Report of the Head of Planning & Enforcement Services

Address 4 HAROLD AVENUE HAYES

Development: Single storey side/rear extension, conversion of roof space to habitable use to include a rear dormer, 3 front rooflights and conversion of roof from hip to gable ends and single storey detached outbuilding to rear for use as store involving demolition of existing detached garage to rear (Application for a Certificate of Lawful Development for a Proposed Development)

LBH Ref Nos: 67940/APP/2011/1760

REVISION	DATE	NOTE

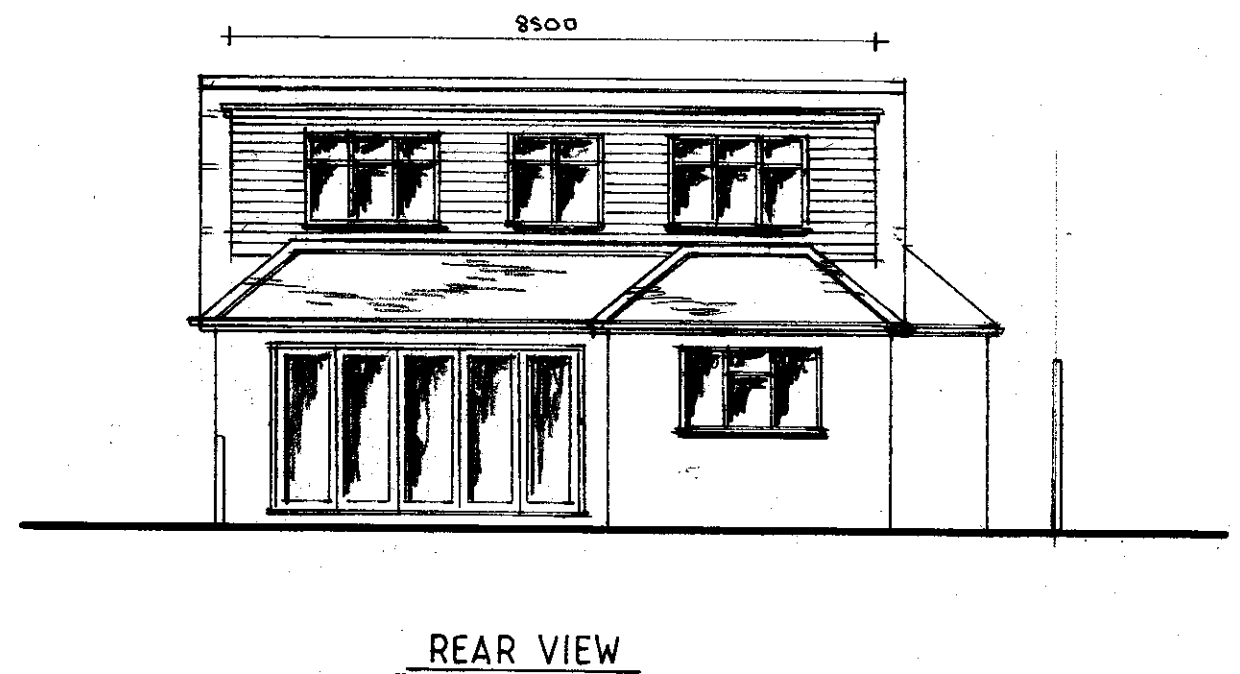
The plans indicate that the combined single storey rear extension, single storey side extension and replacement outbuilding would not cover more than 50% of the ground within the applicant site, excluding the ground area of the existing dwelling.

The proposed single storey rear extension would not extend beyond the rear wall of the original dwelling by 4 metres, would not be more than 4 metres in height and would have eaves below 3 metres in height within 2 metres of the boundary.

The proposed single storey side extension would not extend beyond a side elevation of the original dwelling by a width greater than half the width of the original house, would not be more than 4 metres in height and would have eaves below 3 metres in height within 2 metres of the boundary.

Plans indicate that the hip to gable roof alteration, three roof lights in the principal elevation and rear dormer would:

- i) Not exceed the height of the highest part of the roof,
- ii) Not extend beyond the plane of any existing roof slope which forms part of a principal elevation of the dwelling house and fronts a highway,
- iii) Not exceed the cubic content of the original roof space by more than 50 cubic metres,
- iv) Match the materials of the original dwelling and the rear dormer would be inset by 200mm from the eaves.
- v) Have roof lights less than 150mm above roof plane and lower than highest part of

The plans indicate that the proposed flat roofed outbuilding would not result in more than half the area of land around the original house being covered by additions and other buildings nor extend forwards of the principal elevation of the original dwelling-house. It would be a single storey building, no higher than 2.5 metres, not have an eaves height exceeding 2.5 metres, not be within the curtilage of a Listed Building and does not include the provision of a veranda, balcony or raised platform. The proposed development would therefore meet the criteria to be permitted development under Schedule 2, Part 1, Class E of the Town and Country Planning (General Permitted Development) Order 1995 (as amended).

$7.2\text{m (d)} \times 3.1\text{ (h)} \times 3.5\text{ (w)} = 78.12 / 6 = 13.02\text{ cubic metres per gable end}$

Total of two hip to gable conversions = $13.02 \times 2 = 26.04\text{ cubic metres}$

$8.5\text{m (w)} \times (2.5\text{m (d)} \times 2.2\text{ (h)}) = 46.75/2 = 23.375\text{ cubic metres}$

Total volume added $23.375 + 26.04 = 49.414\text{ cubic metres.}$

The measurements on the plans have been checked and the proposed hip to gable conversion and rear dormer would add less than 50 cubic metres to the original dwelling.

1604 | 3

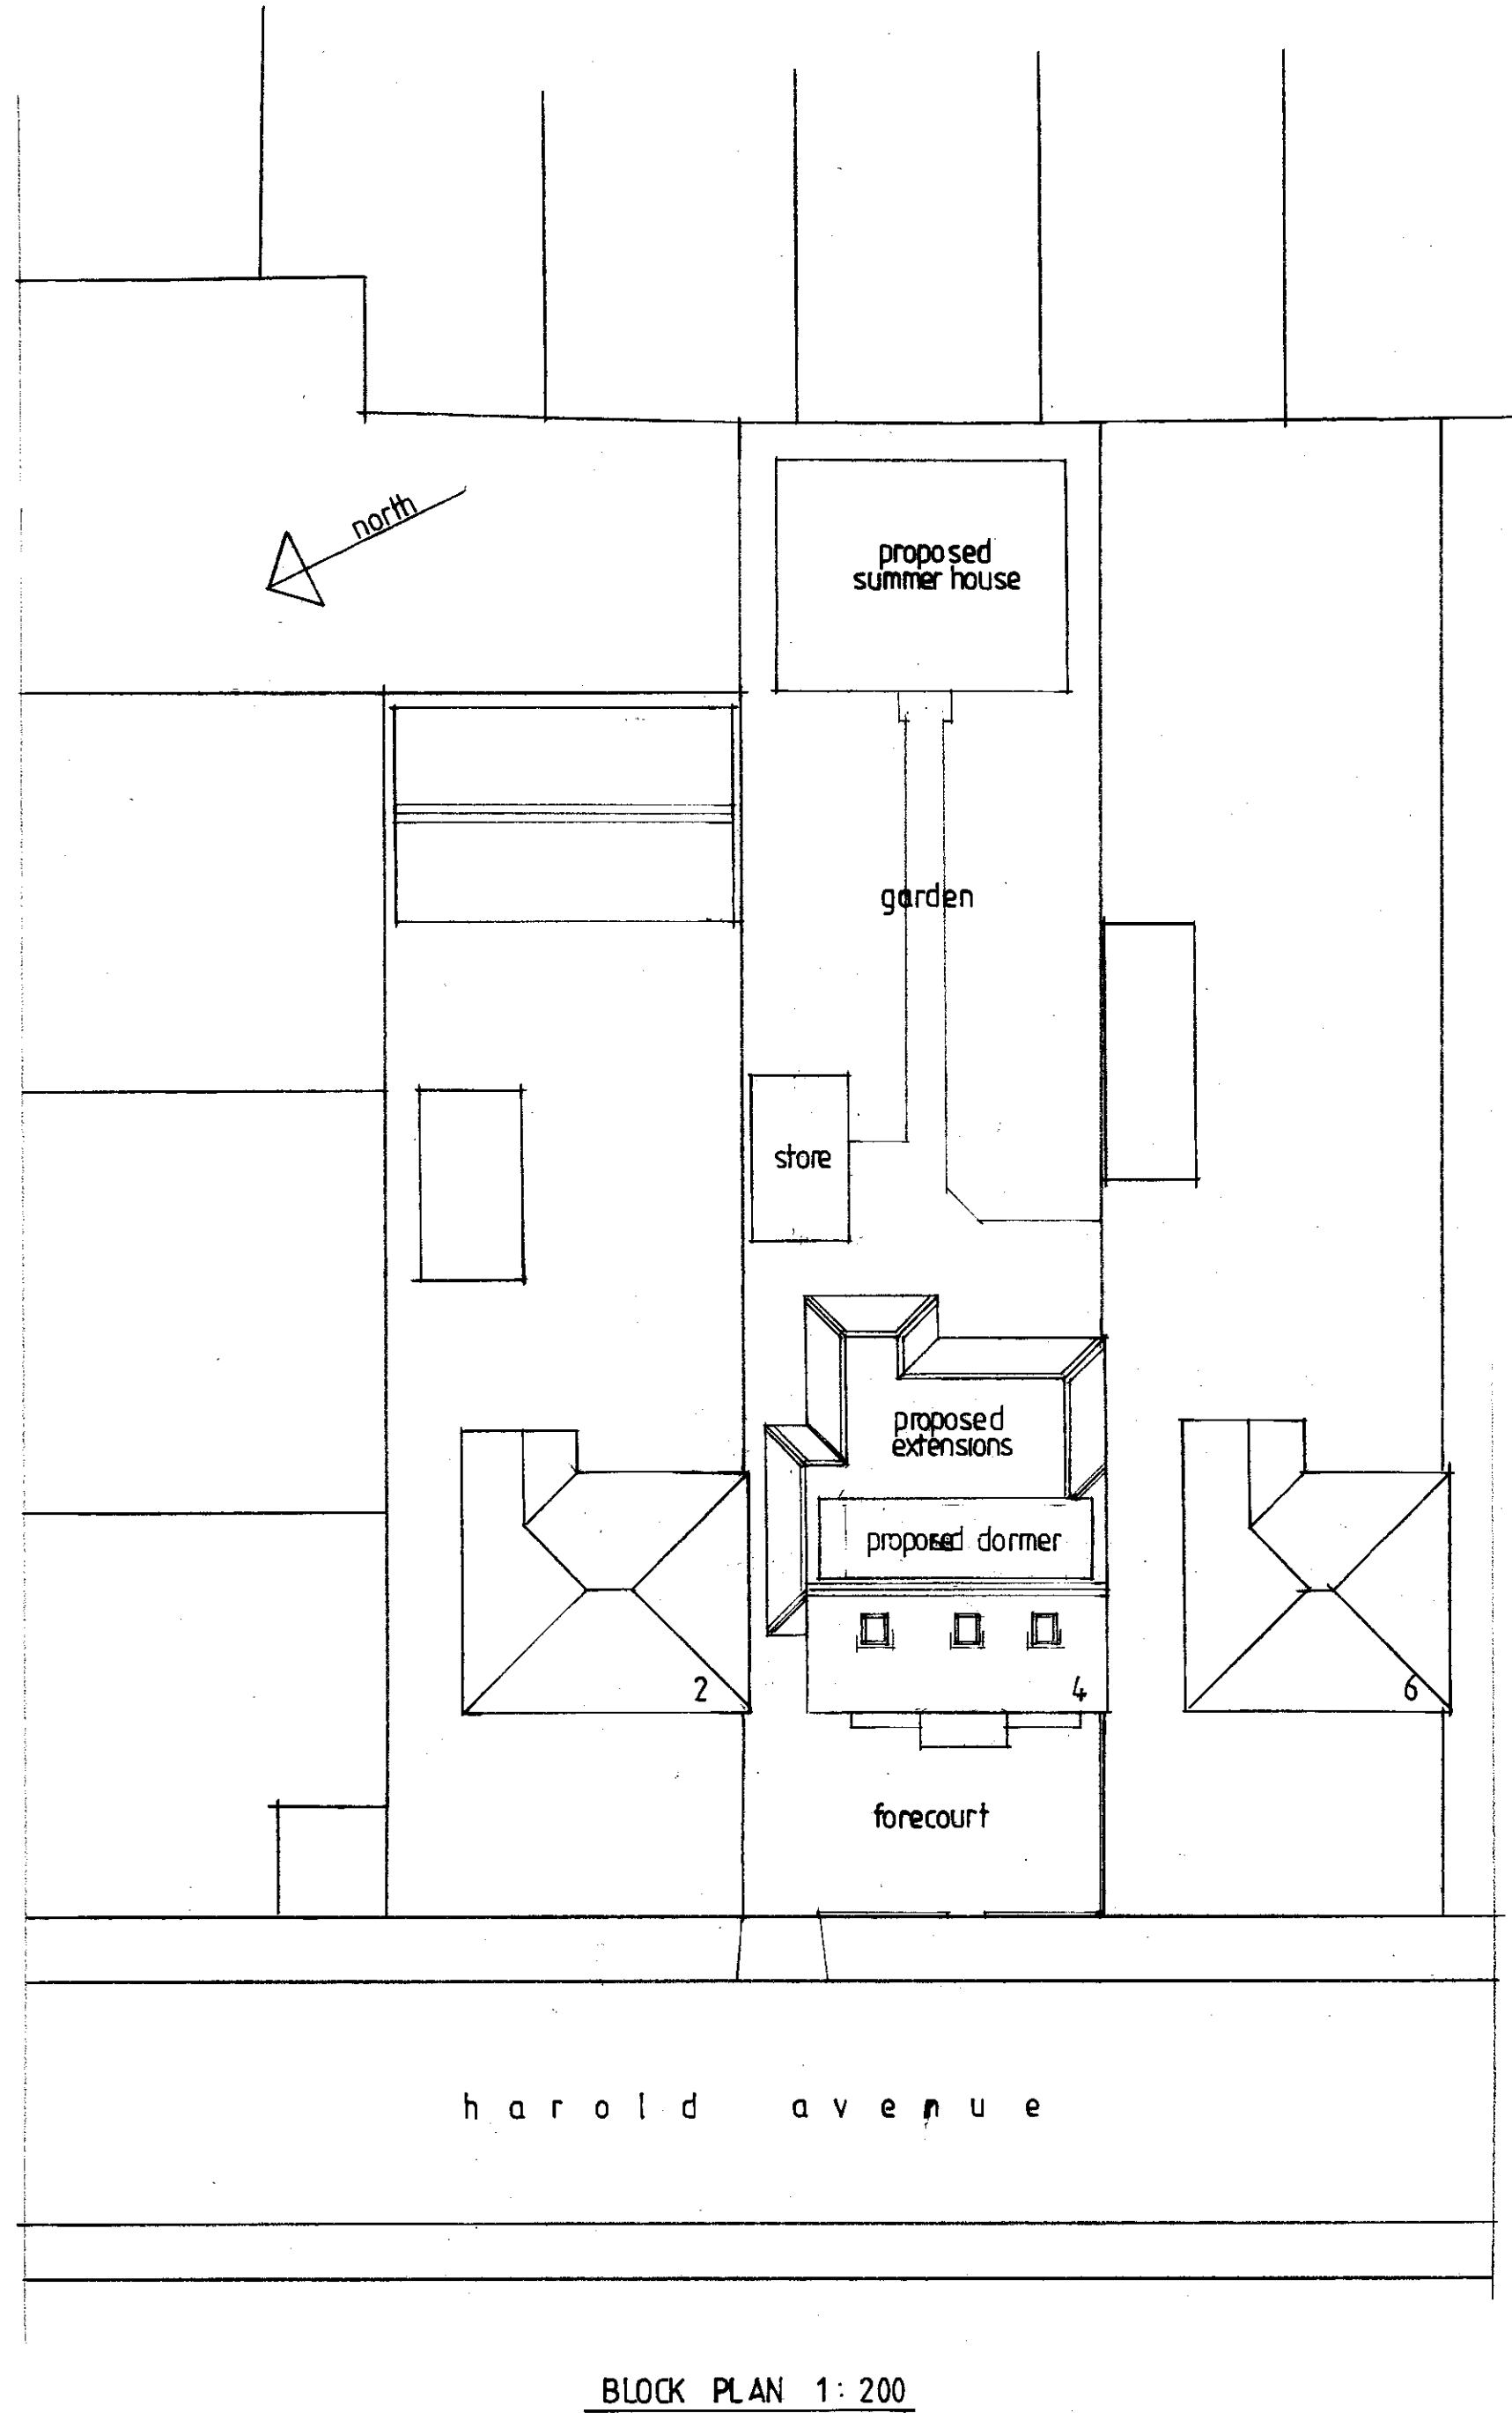
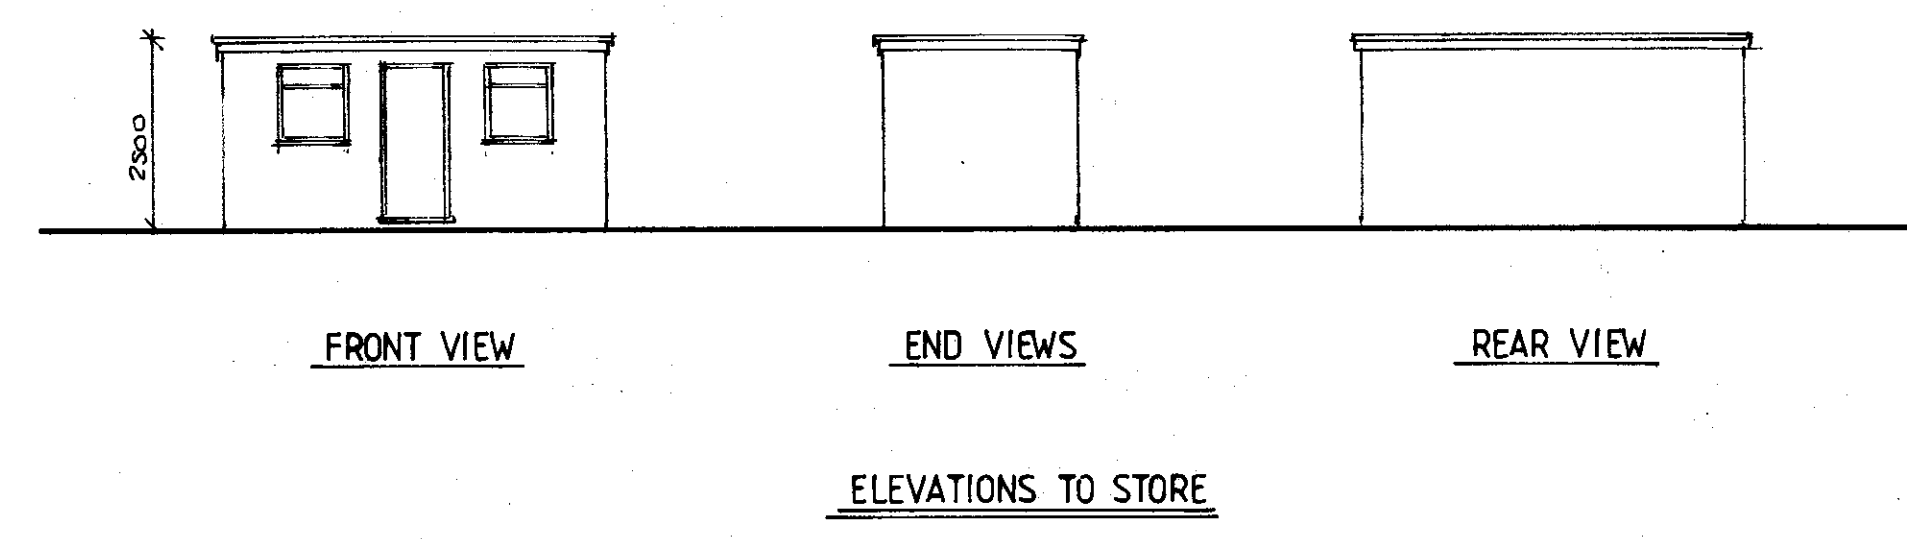
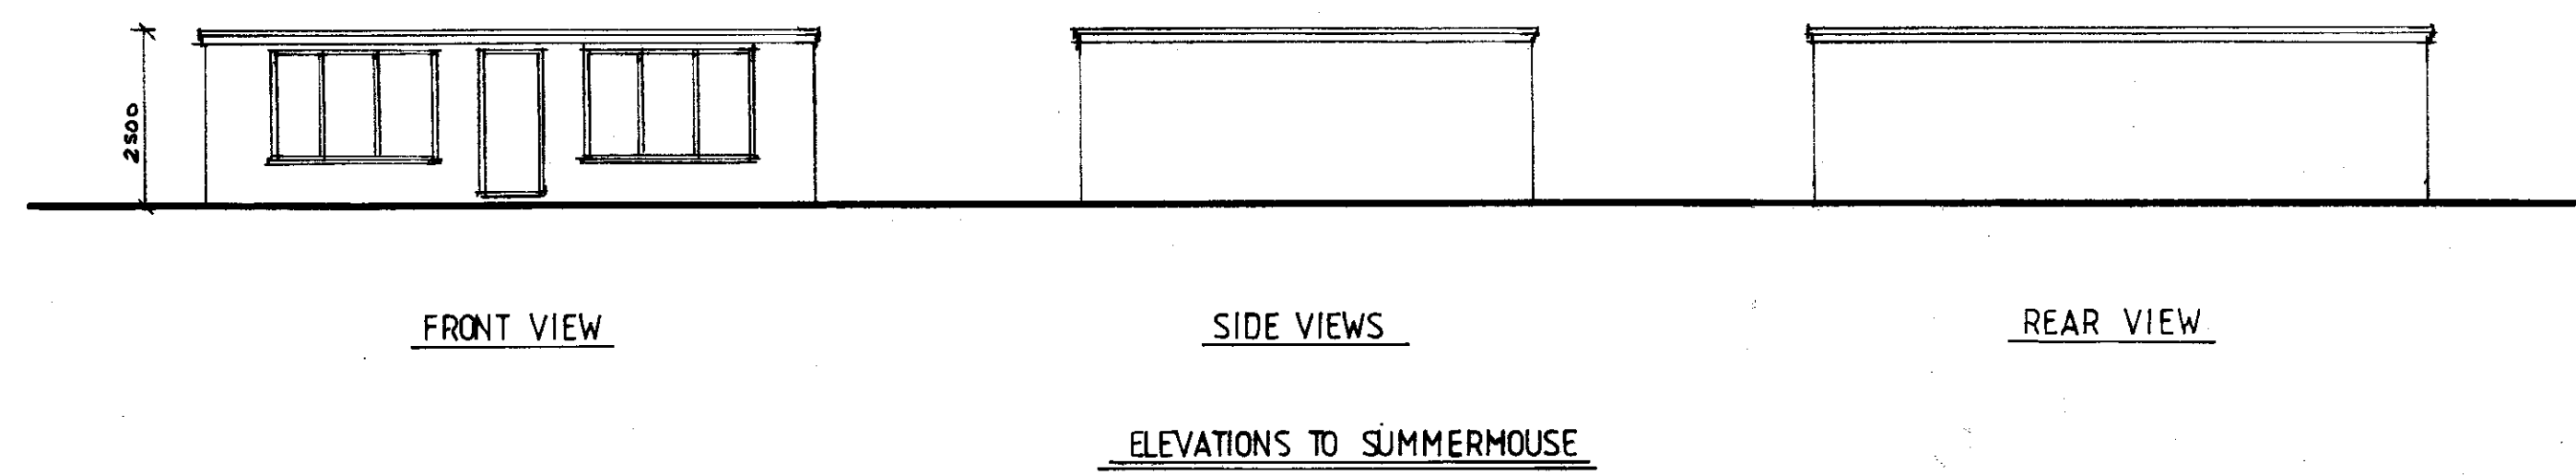
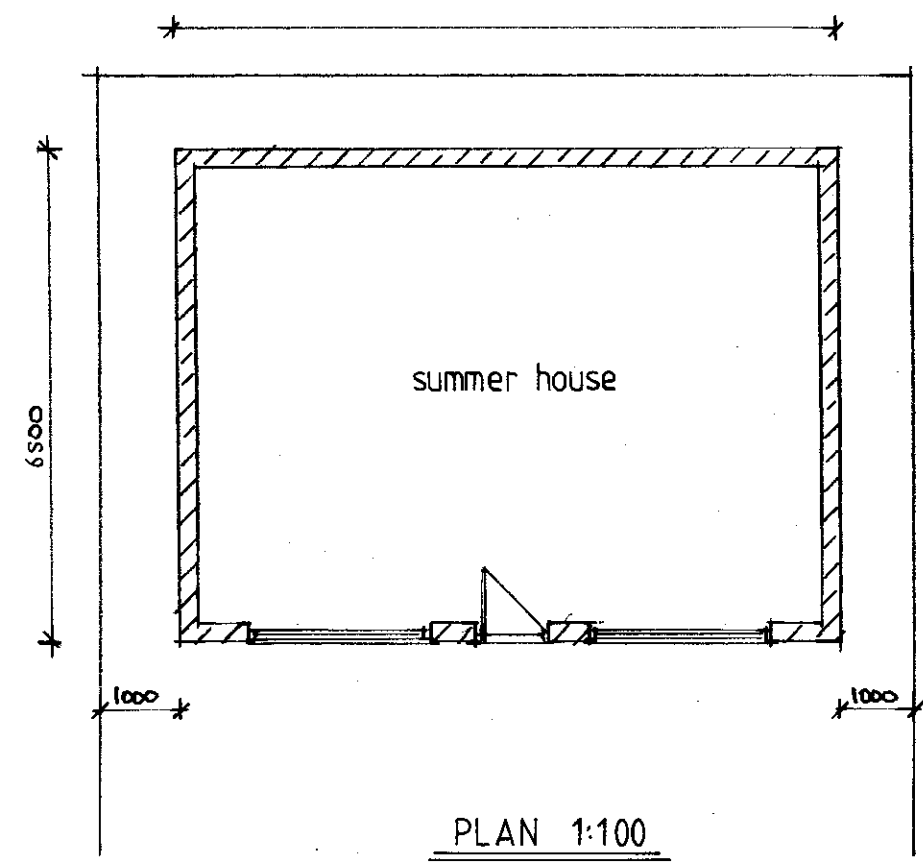
- 2 The proposed summerhouse indicated on plan reference number 1604/3 has not been determined as part of this granted Lawful Development Certificate.

The submitted application and plans included the erection of an additional outbuilding at the rear of the garden. In an e-mail to the Local Planning Authority dated 18th August 2011, the applicant asked for this to be removed from the application and for it to be determined without this additional outbuilding.
